COMMUNITY SERVICES DEPARTMENT

Subject: Walden Preserve 2 Filing No. 5 Final Plat (SF2211)

Walden Preserve 2 Filing No. 5 Final Plat

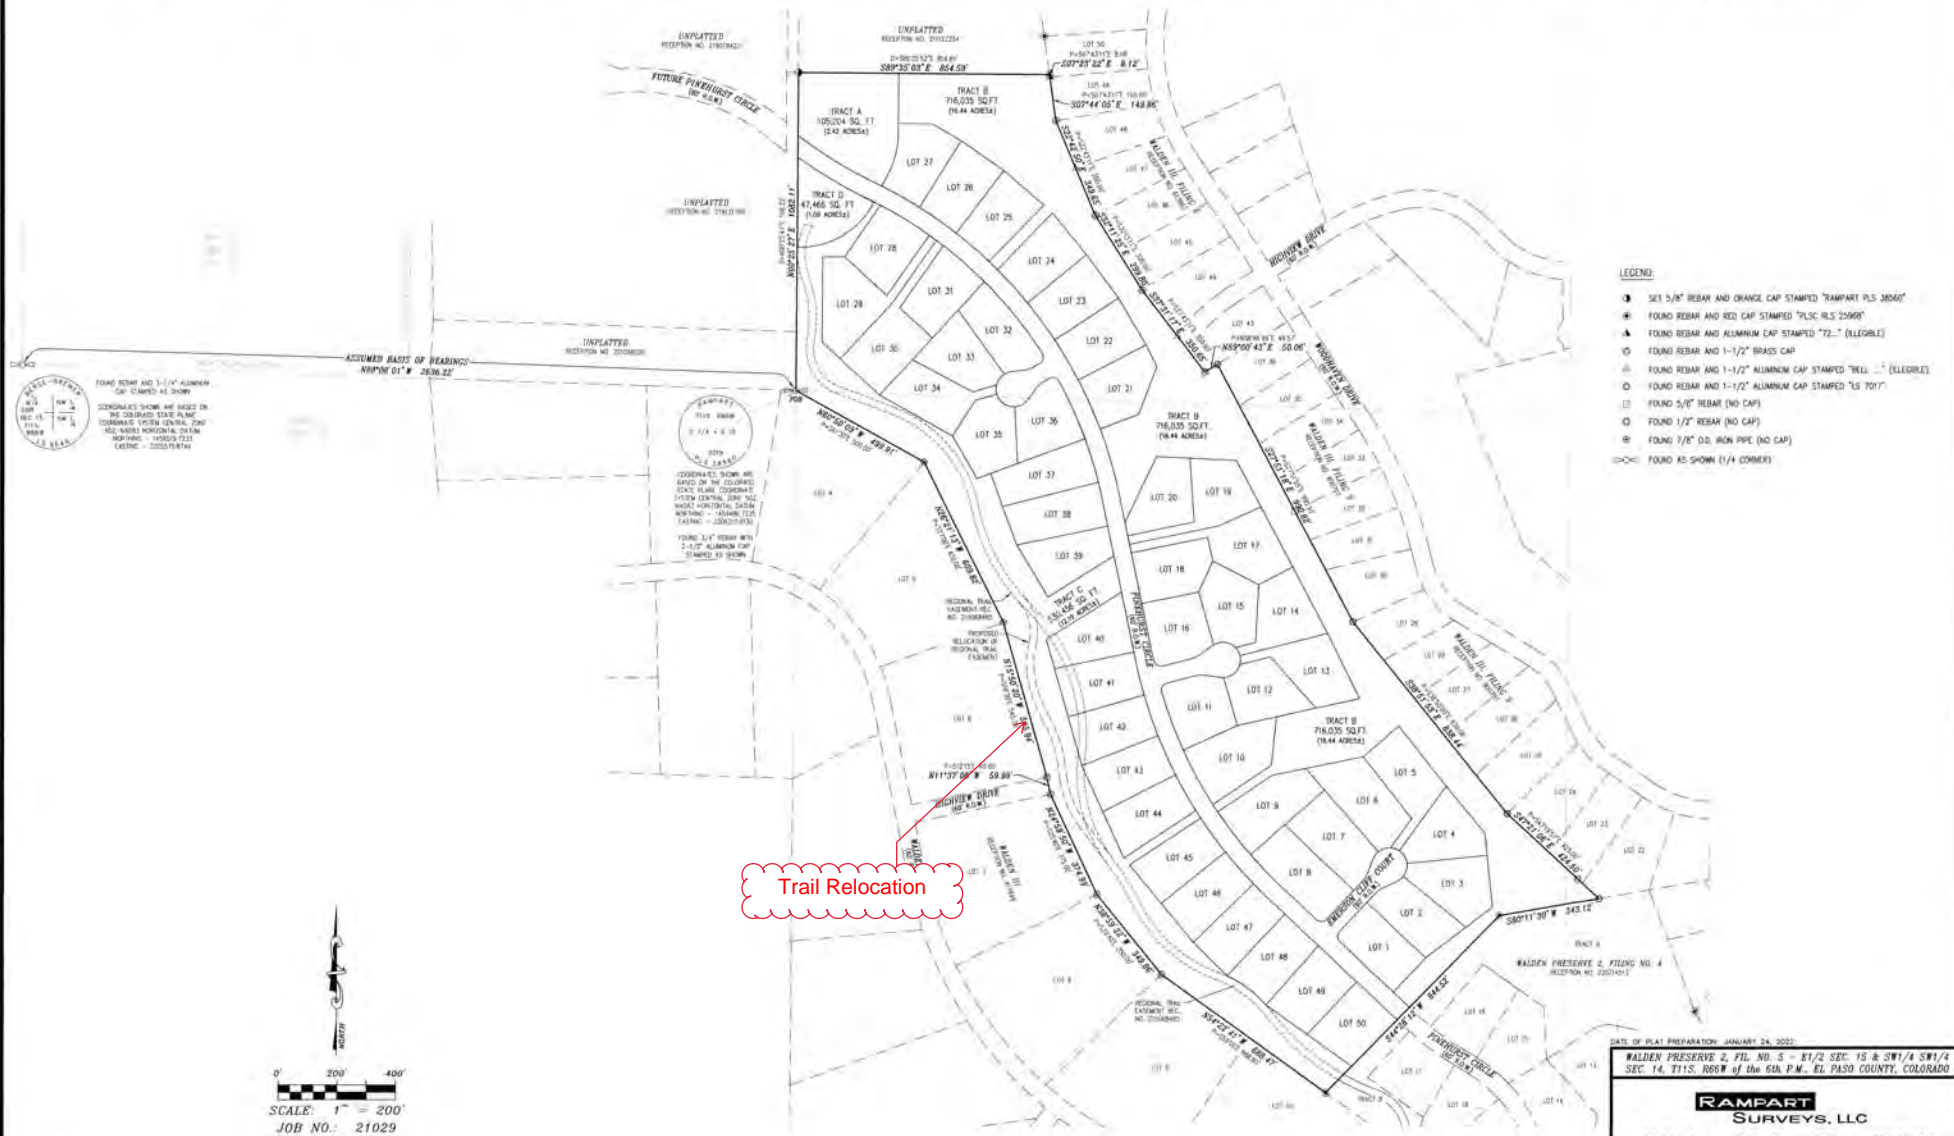
The Filing No. 5 includes a section of the previously constructed Cherry Creek Trail. However, the applicant is proposing a realignment of the trail within Tract C near Lots 40-43. Since this section of trail was already constructed per a PLA, and a trail easement provided to the County, the applicant shall be responsible for the relocation of the trail. The applicant shall also provide a revised trail easement to reflect the relocation. The applicant should also take care to protect the existing trail from construction impacts and will be responsible for any required trail restoration.

Construct Trail and Revise Easement

Recommend to the Planning Commission and Board of County Commissioners that approval of Walden Preserve 2 Filing No. 5 Final Plat include the following conditions: (1) Require fees in lieu of land dedication for regional park purposes in the amount of \$23,000 and urban park fees in the amount of \$14,500; (2) Developer shall be responsible for relocation and construction of the existing Cherry Creek Trail within Tract C; (3) Show on this Final Plat and dedicate to El Paso County a 25-foot trail easement within Tract C that allows for public access, as well as construction and maintenance of the Cherry Creek Secondary Regional Trail.
